**From:** Brenda Larsen  
**Sent:** Friday, January 03, 2014 10:44 AM  
**To:** Jeff Watson  
**Subject:** RE: BL-13-00030 Plum Creek

Re: Plum Creek (BL-13-00030)

BOUNDARY LINE ADJUSTMENT FOR SHAWN SMITH

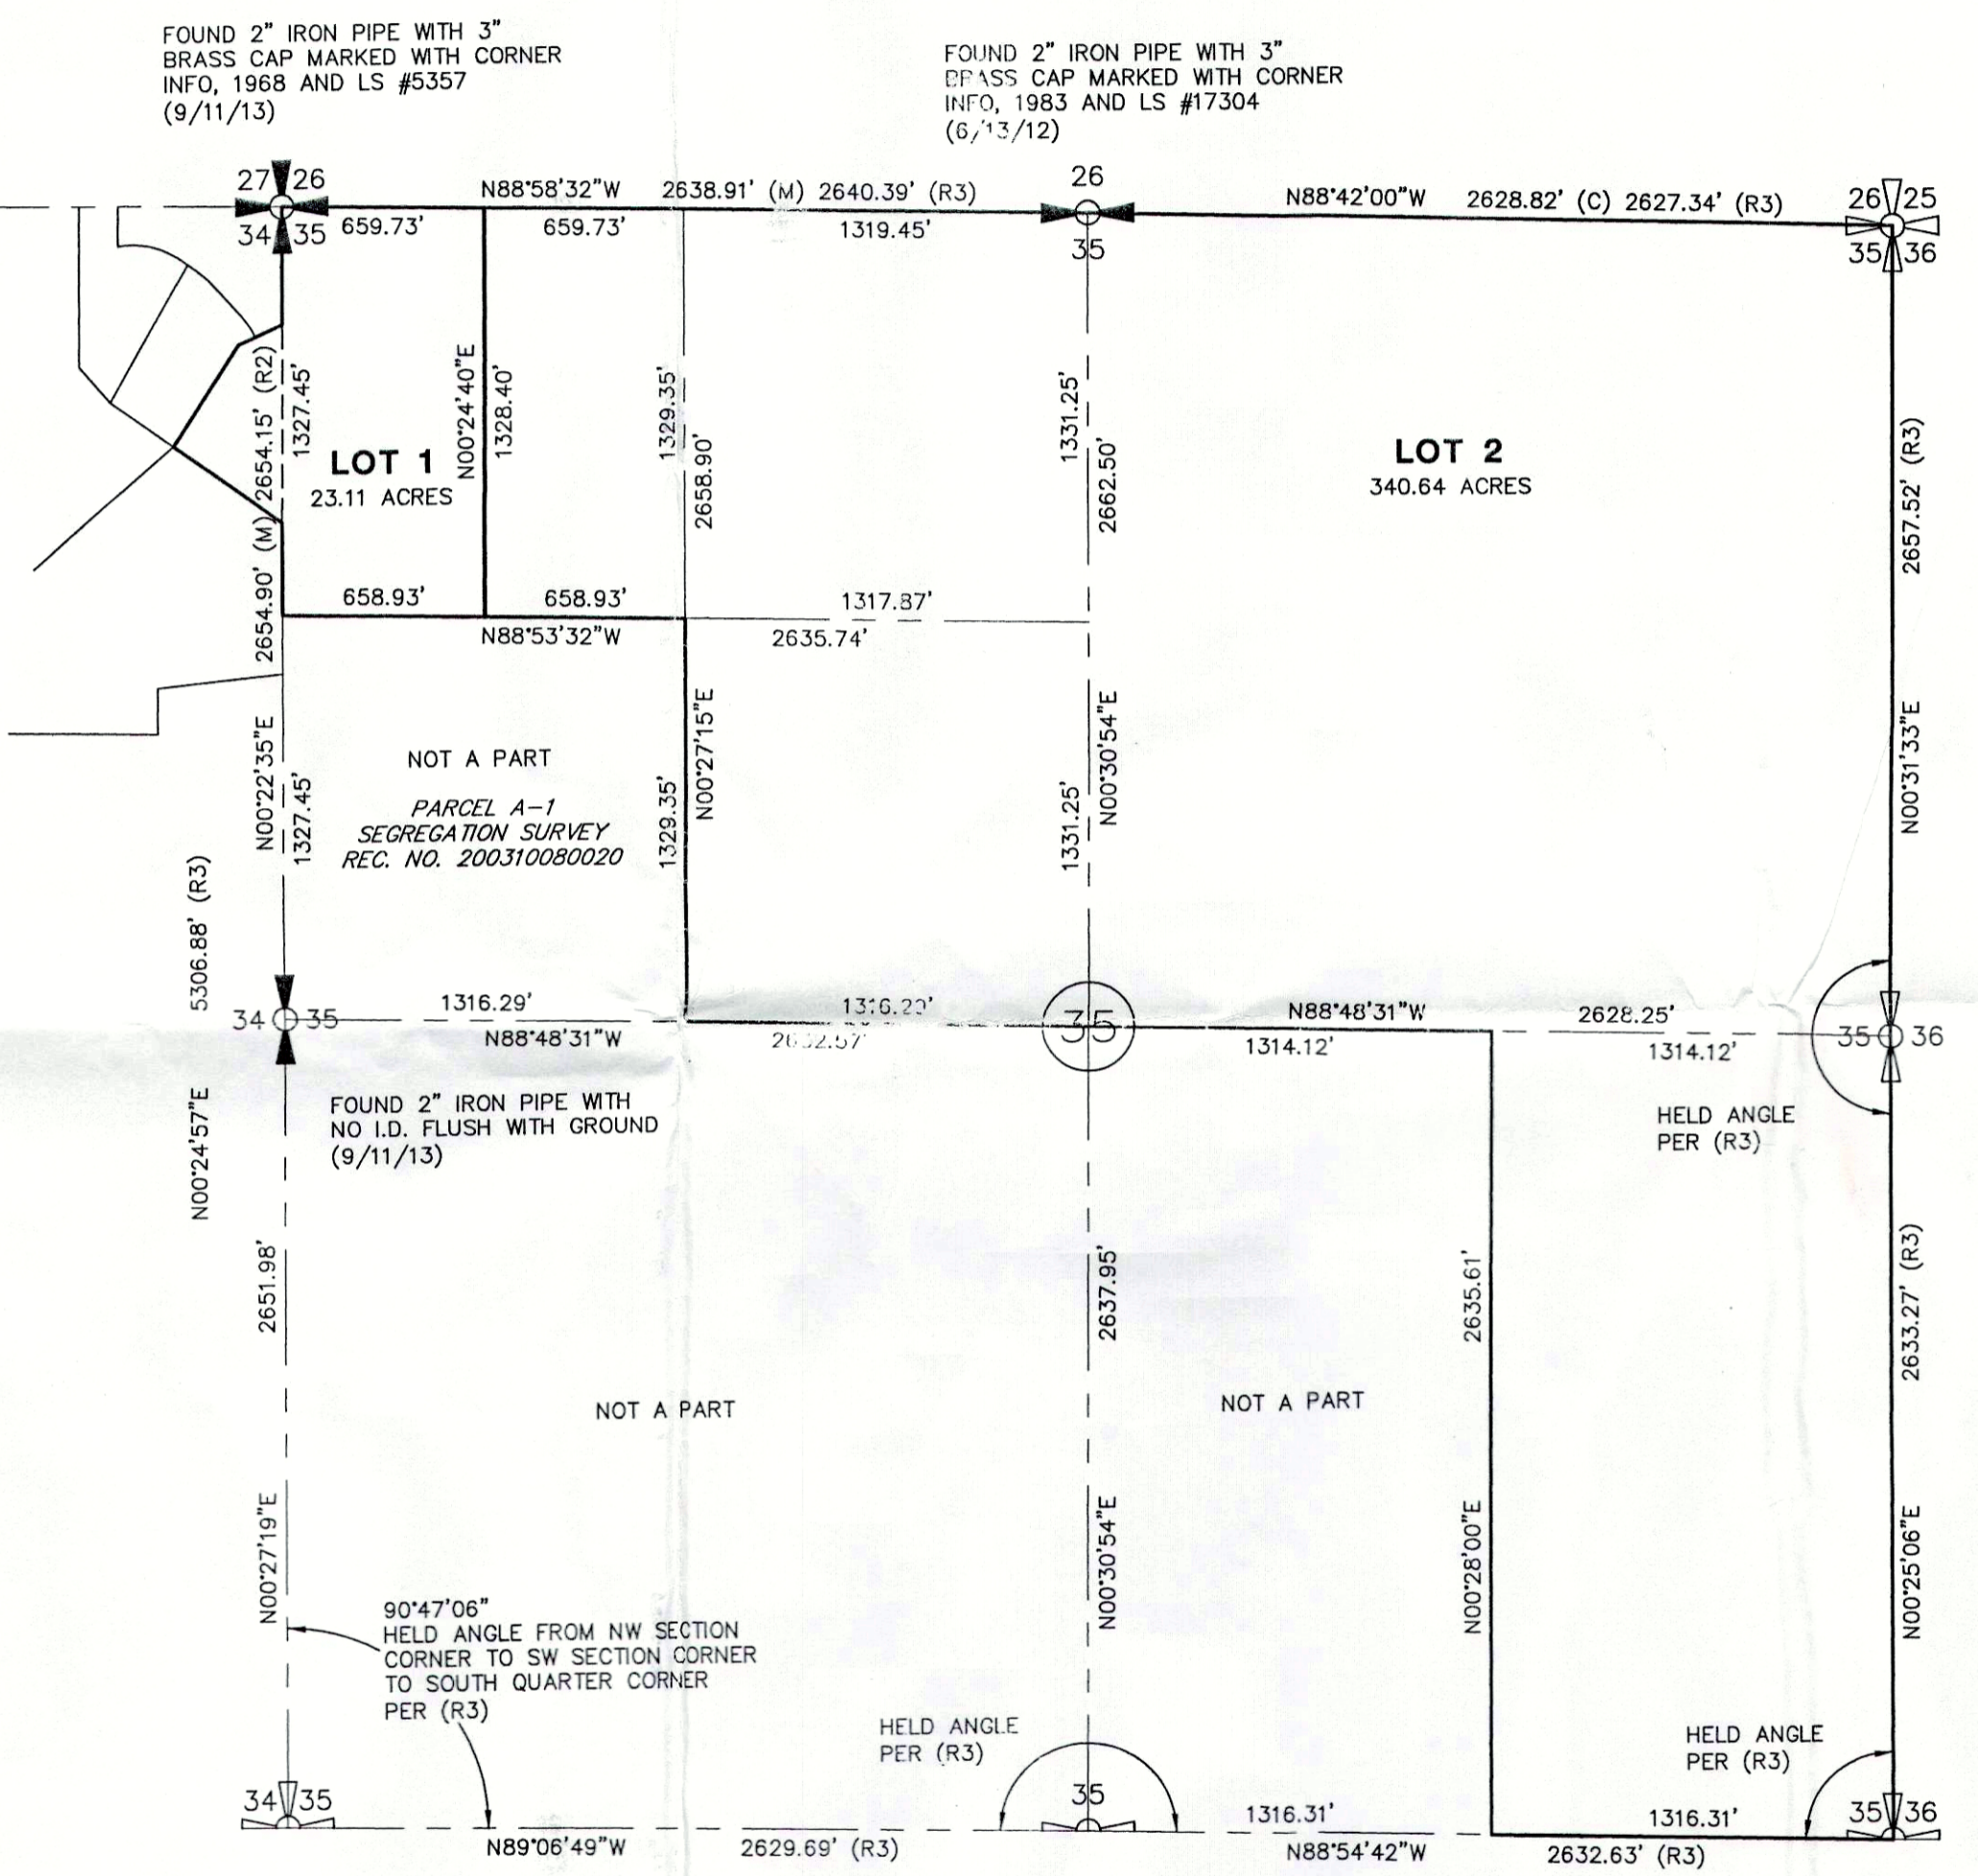
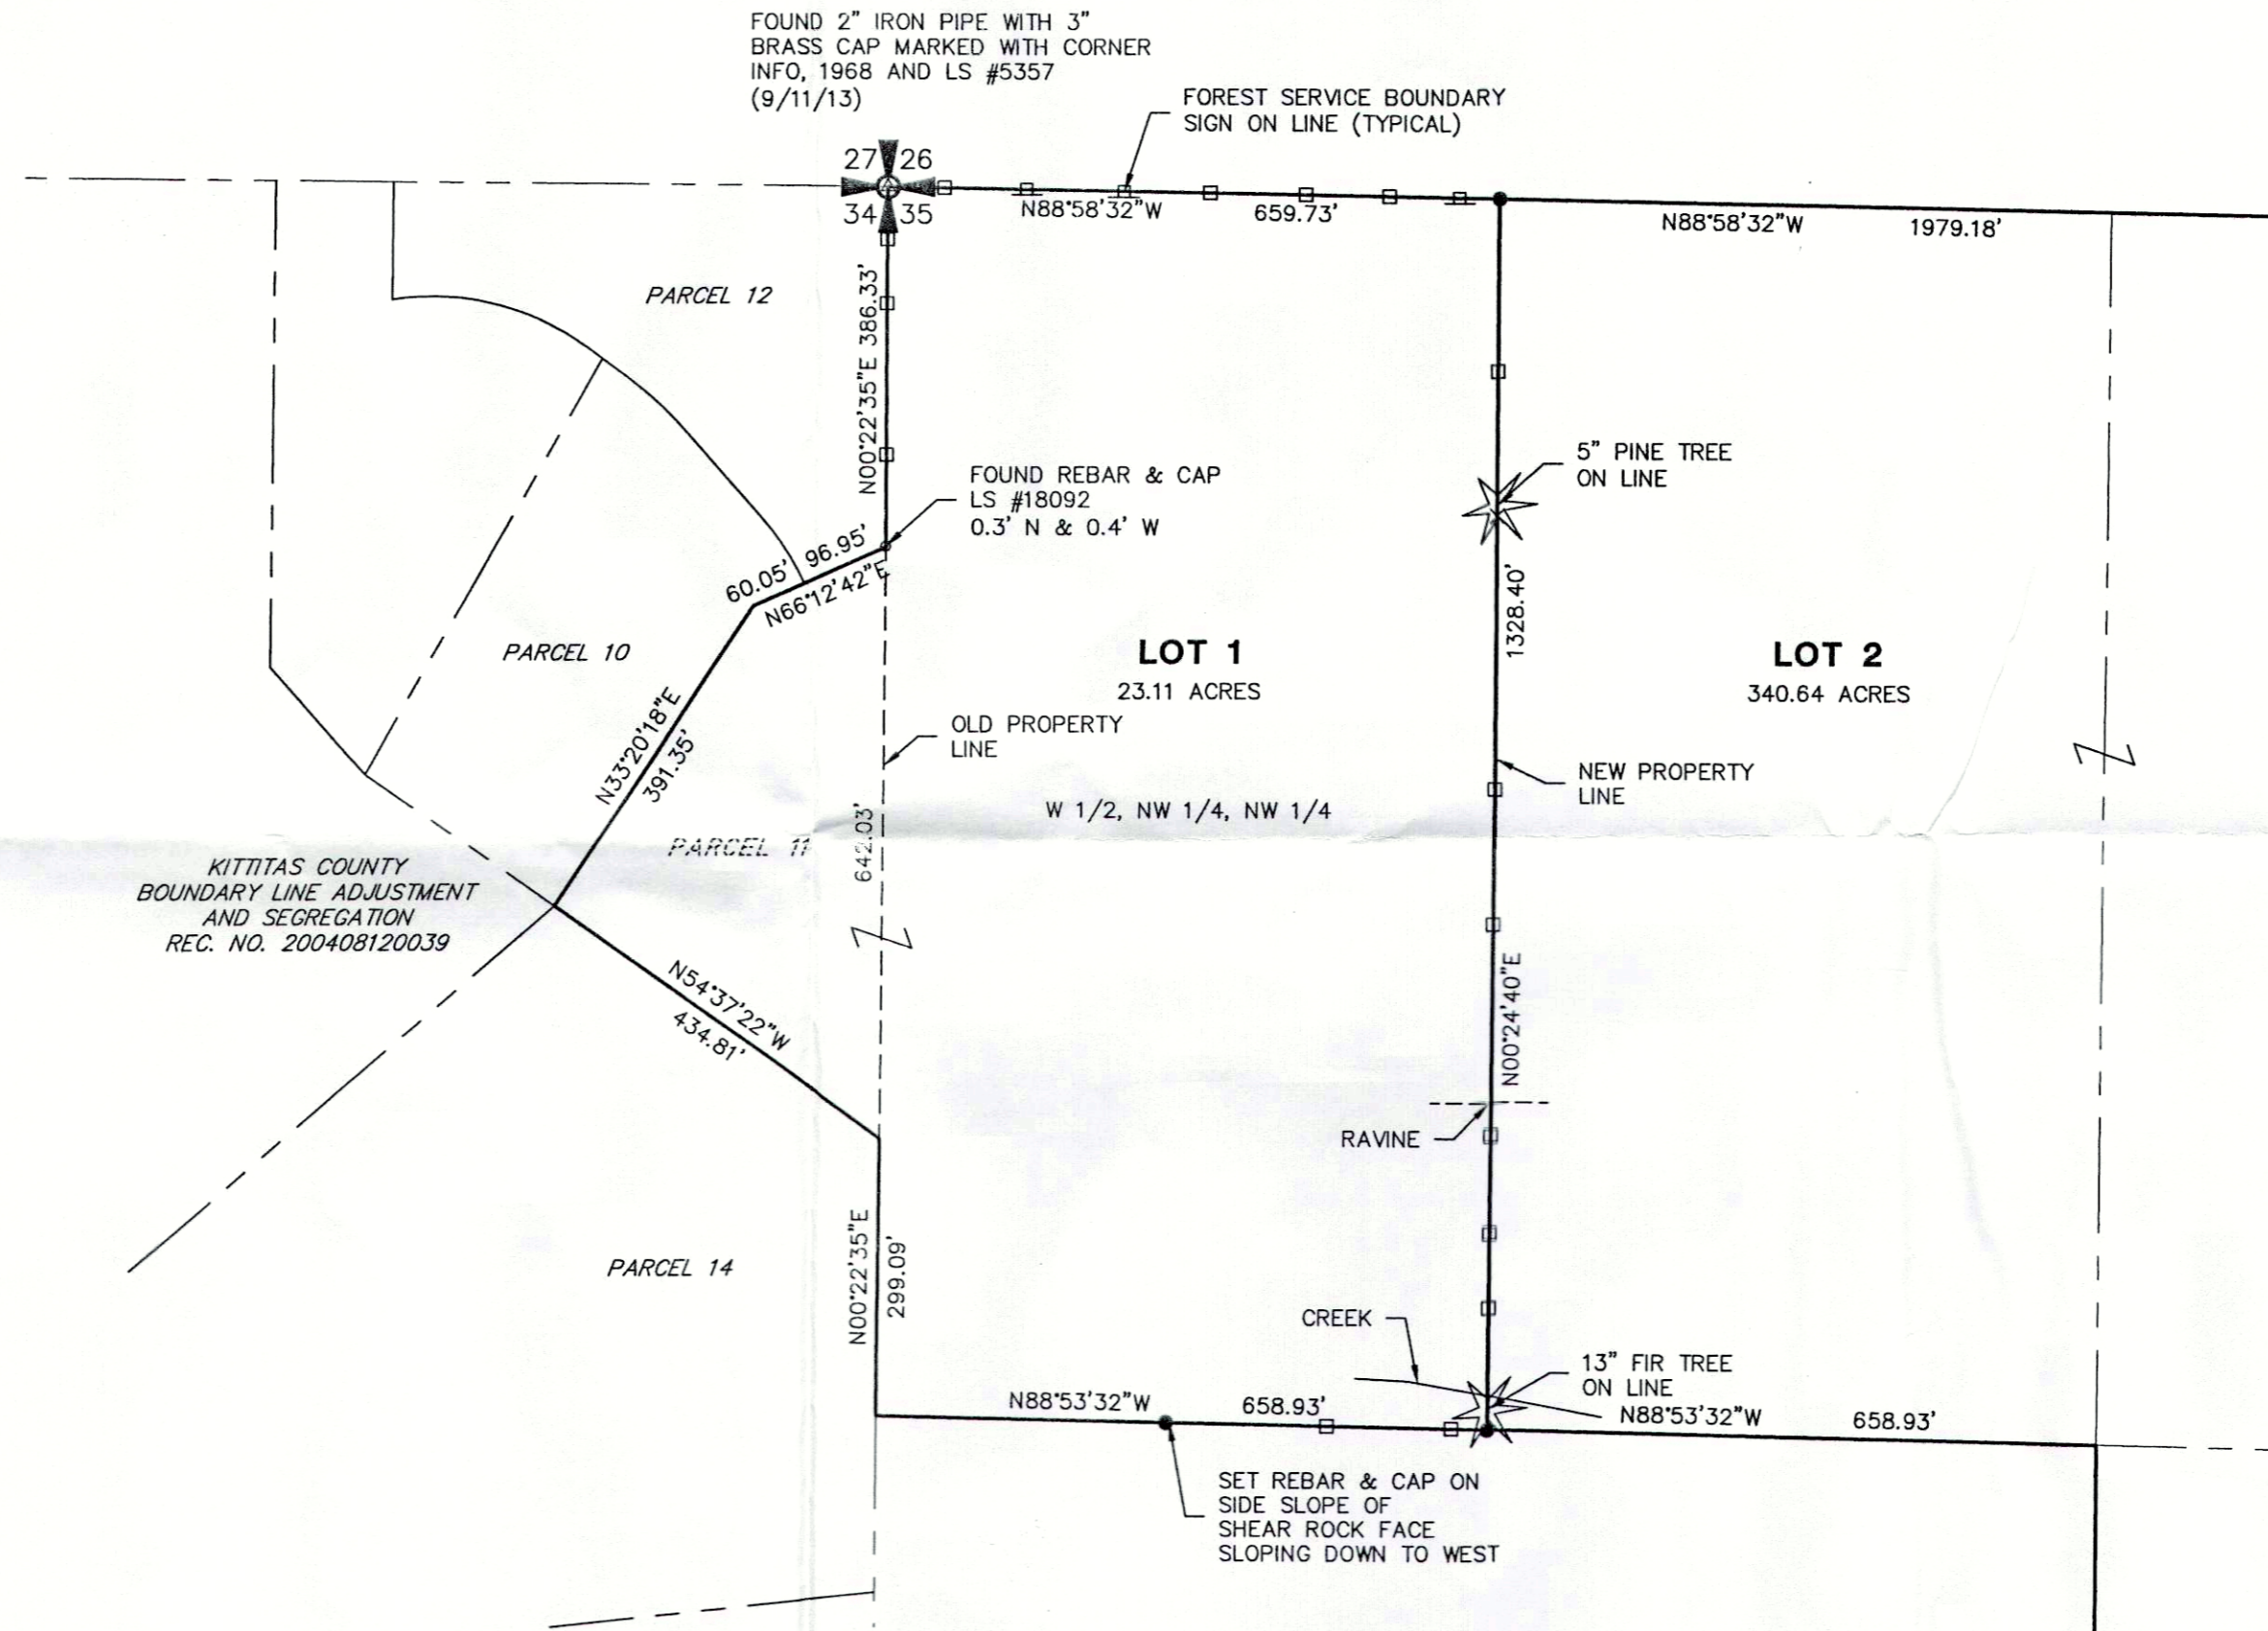
- Ensure that boundary line adjustments do not infringe upon existing structures, to include propane tanks, etc.
- Ensure adequate access for fire apparatus. Any driveways or access points created based off the new lot configurations shall comply with Kittitas County Code 20.02.030.
- All future development must comply with the International Fire Code.
